Tel: 01903 737756
Email: planning@arun.gov.uk
www.arun.gov.uk/planning
Please ask for: Laura Mills
Email: laura.mills@arun.gov.uk
Telephone: 01903737794
Our Ref: FP/91/26/PL
Your Ref:
Date: 21st July 2026

Application for Planning Permission

Development: The replacement of an existing estate maintenance shed located on land owned and maintained by the Roundle Residents Association Ltd., The shed is outside the demise of any residential property.
Location: Land Adjacent To 10 Roundle Square Felpham Bognor Regis PO22 8LB

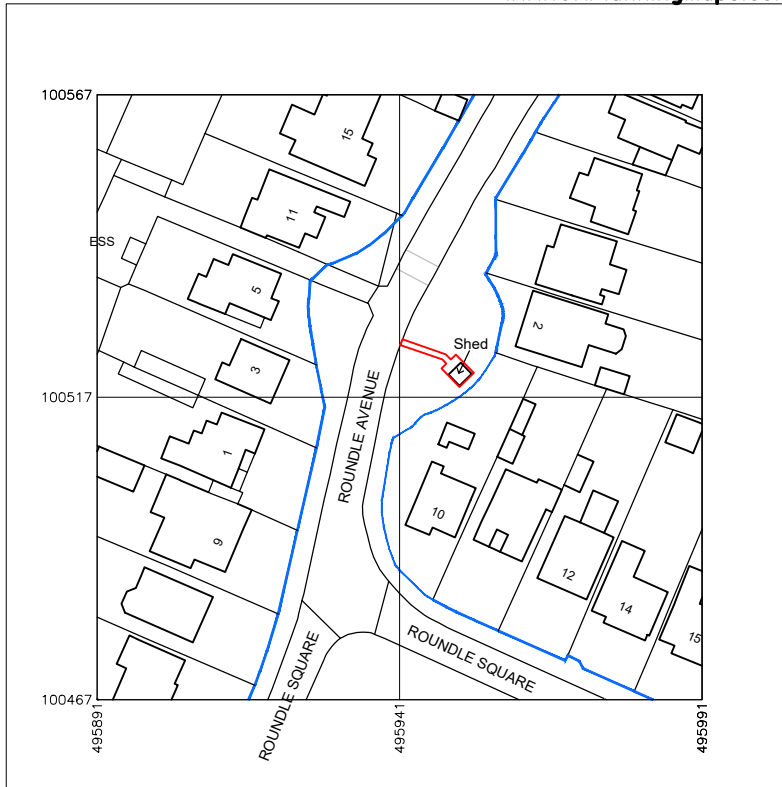
The location plan must show an access path to the shed, please include this within the red edge of the plan.

drawing title
Block Plan

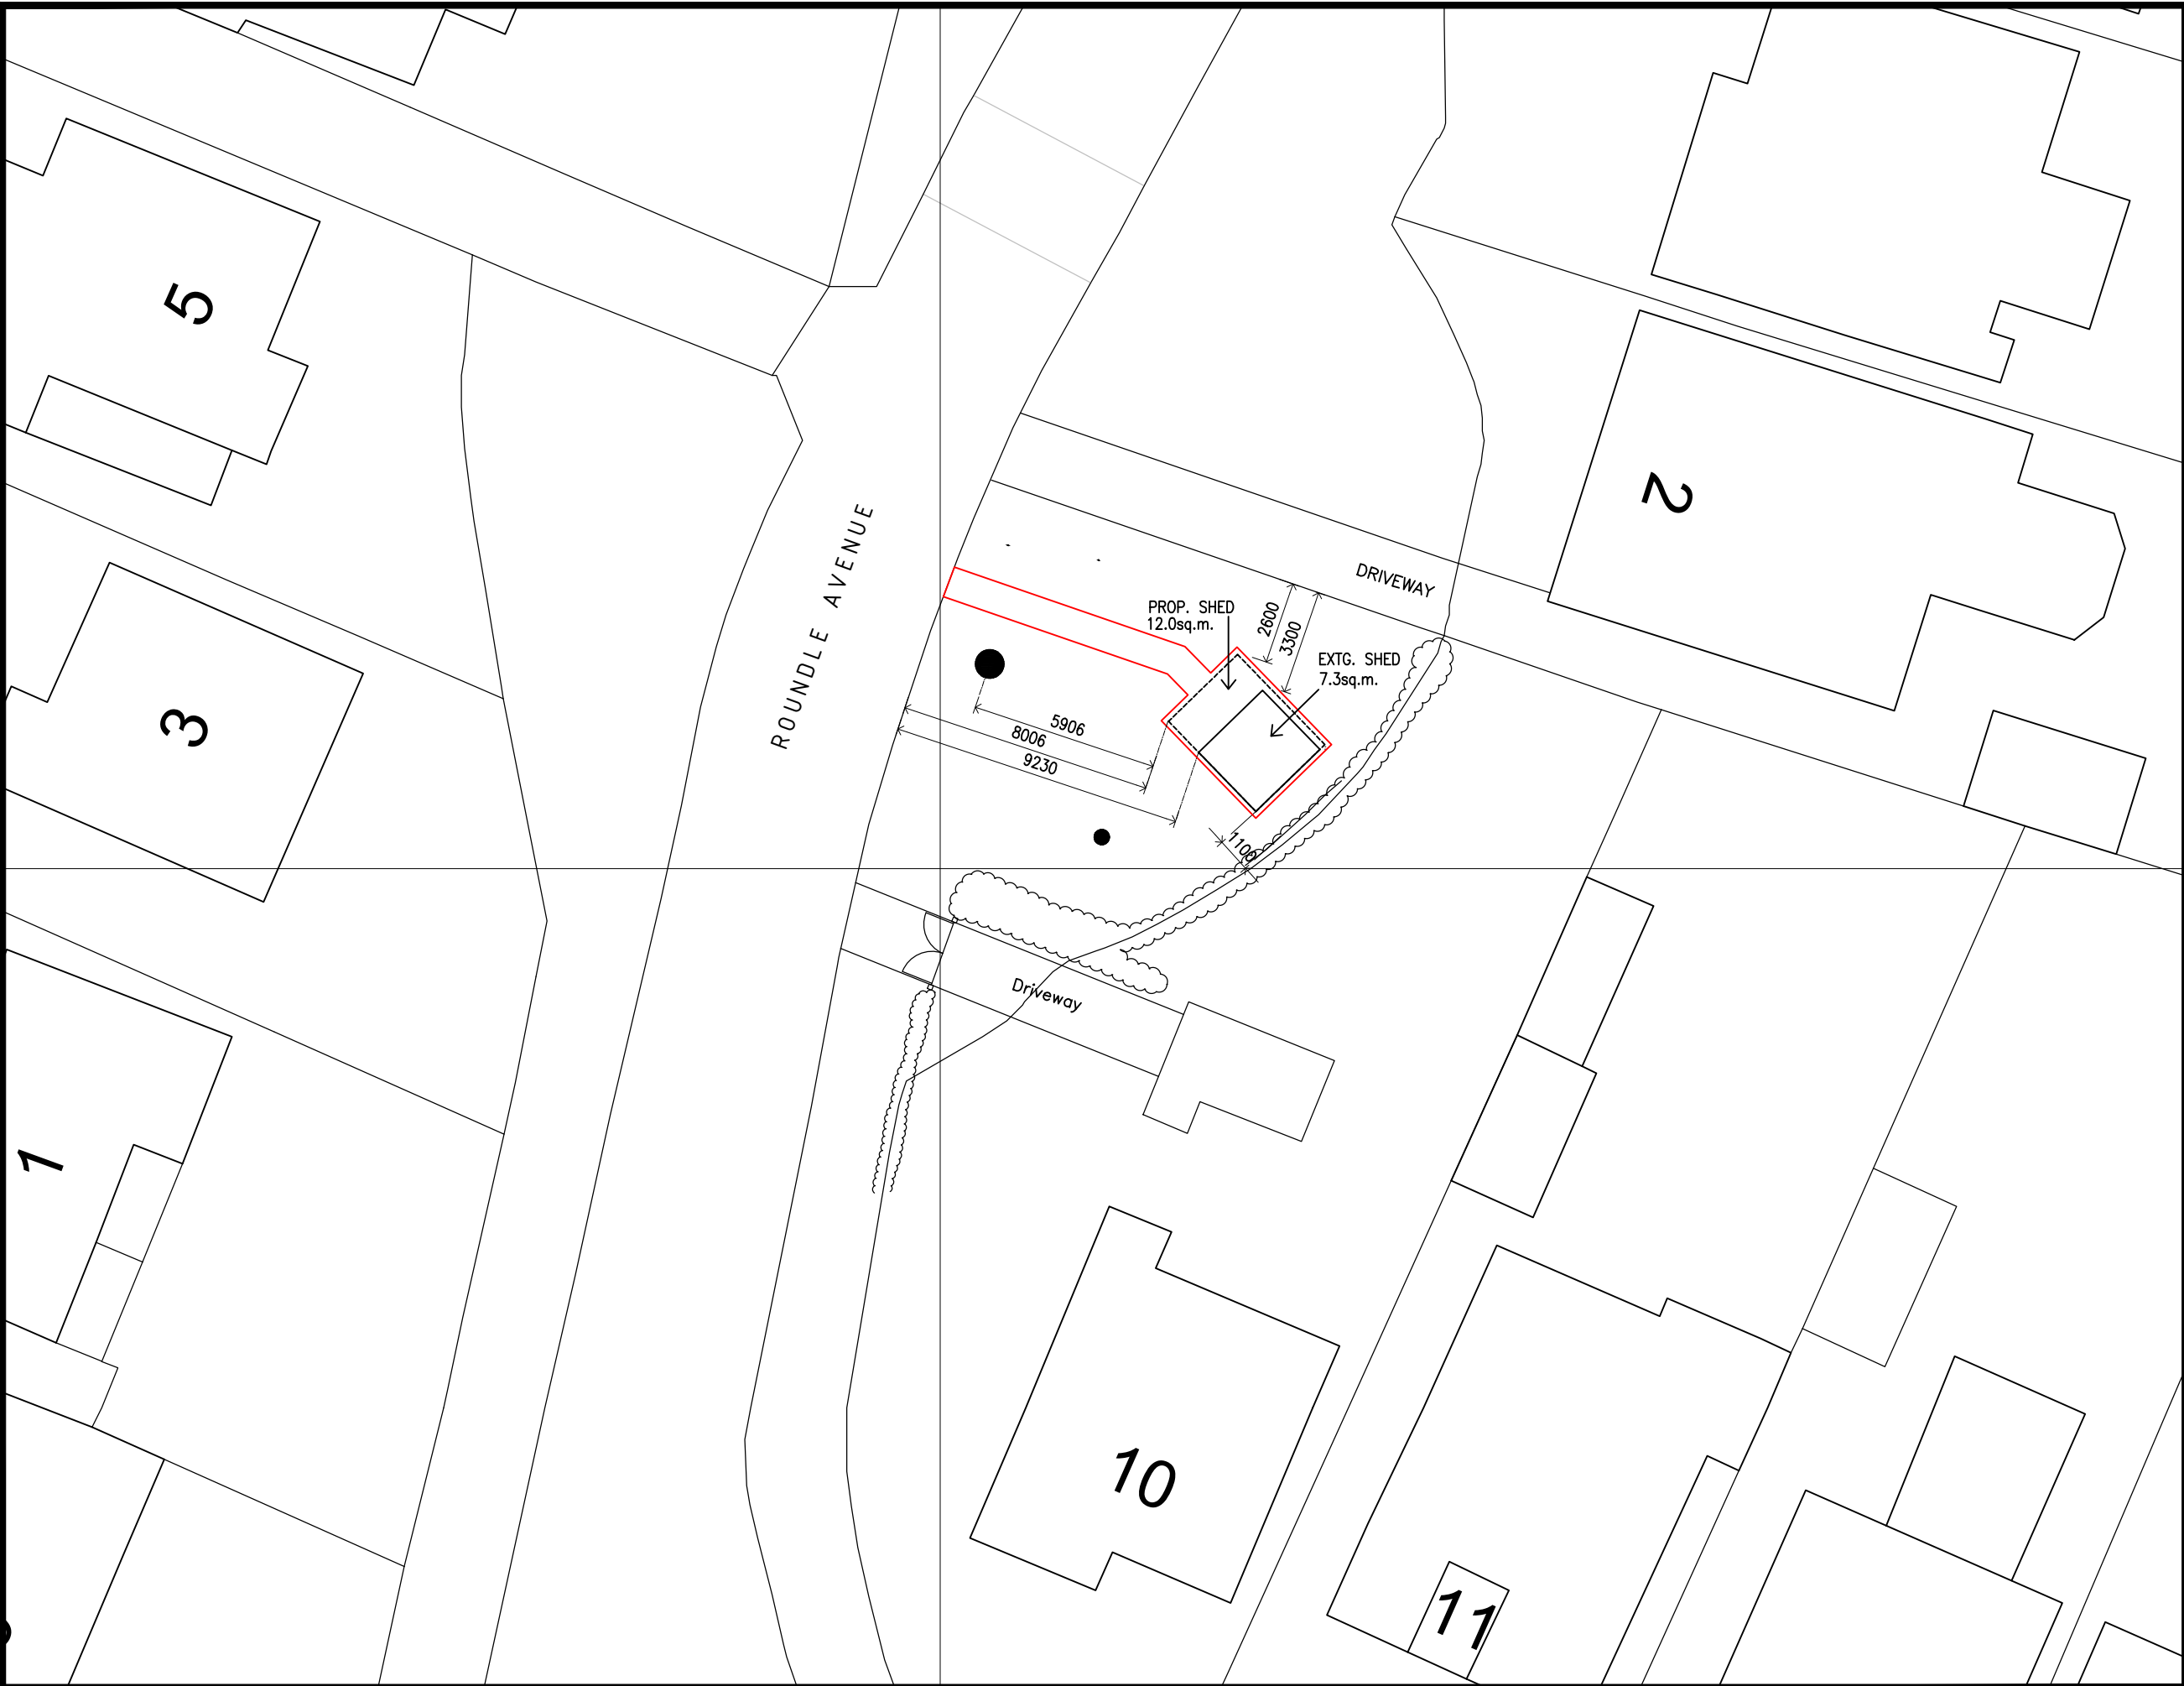
You have submitted a block plan at the scale of 1:100. For validation requirements, please amend to either 1:200 or 1:500.

drawing title Existing and Proposed Shed Plans and Elevations.		
drawn by -	date June 2026	checked
job no. 007	drawing no. 05	revision A

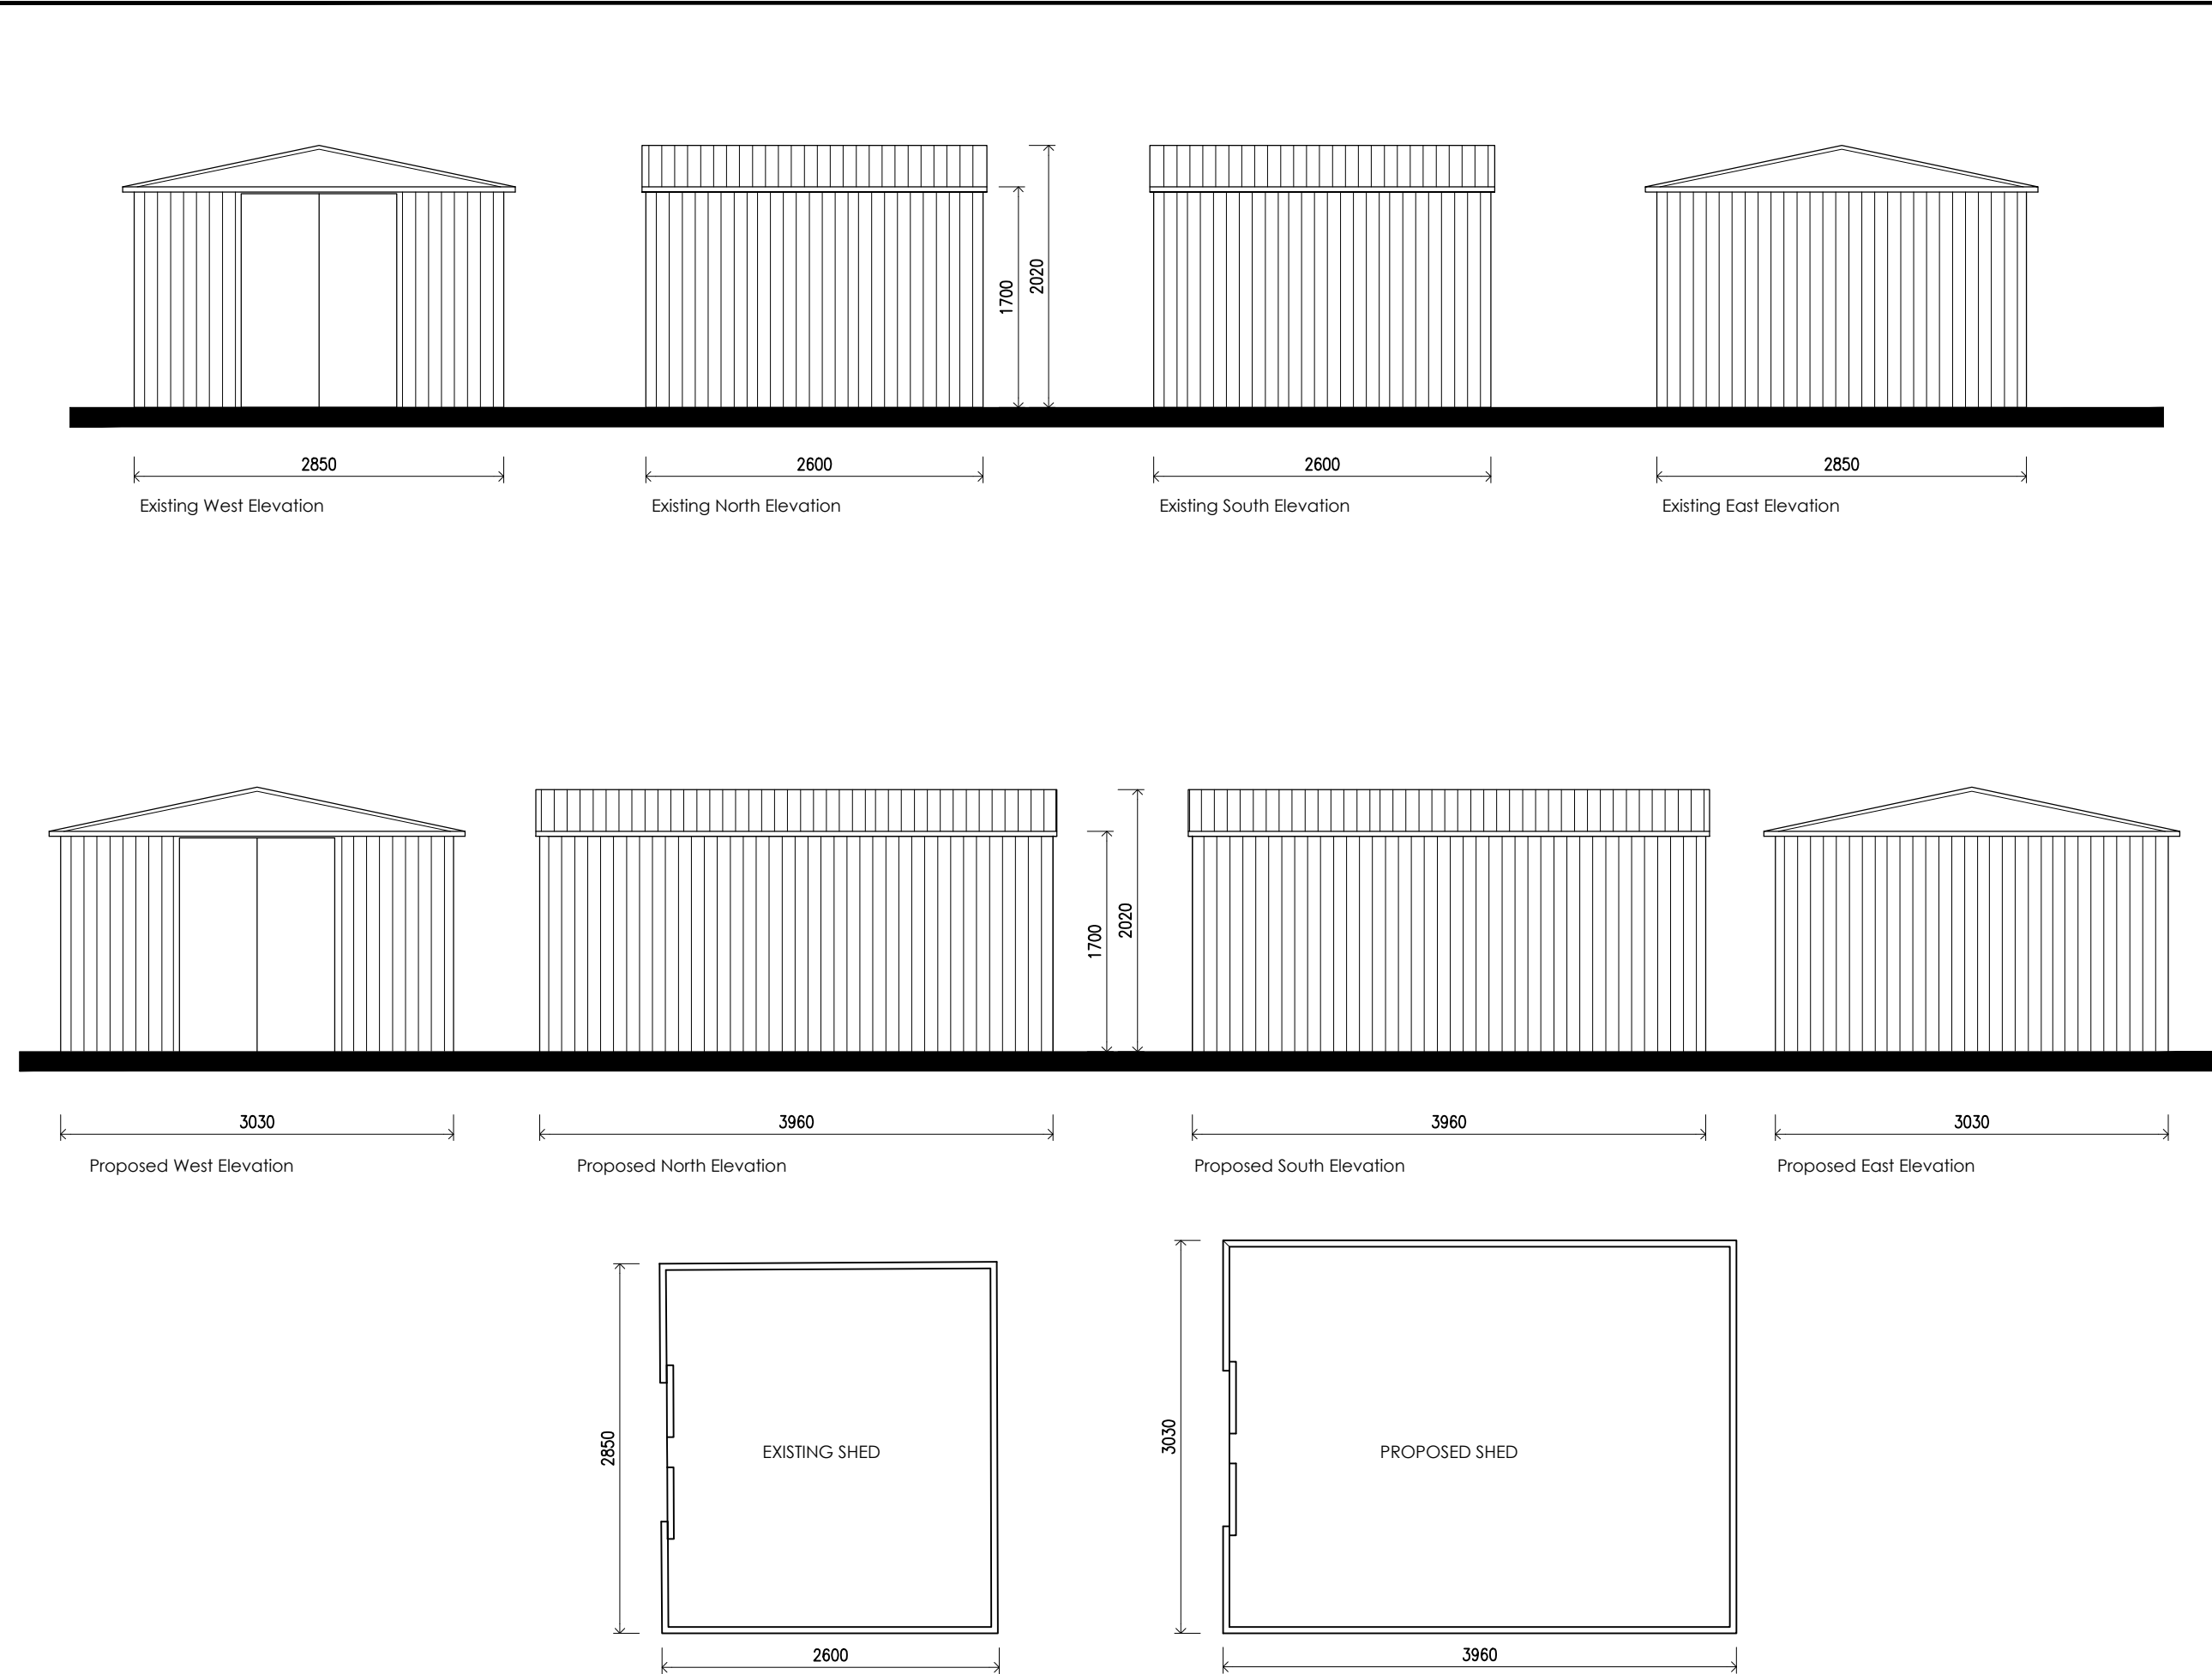
The elevations of the shed are not scaling correctly. Plans must be scanned to actual document size (not to fit) to enable us to be able to measure correctly. Please amend.
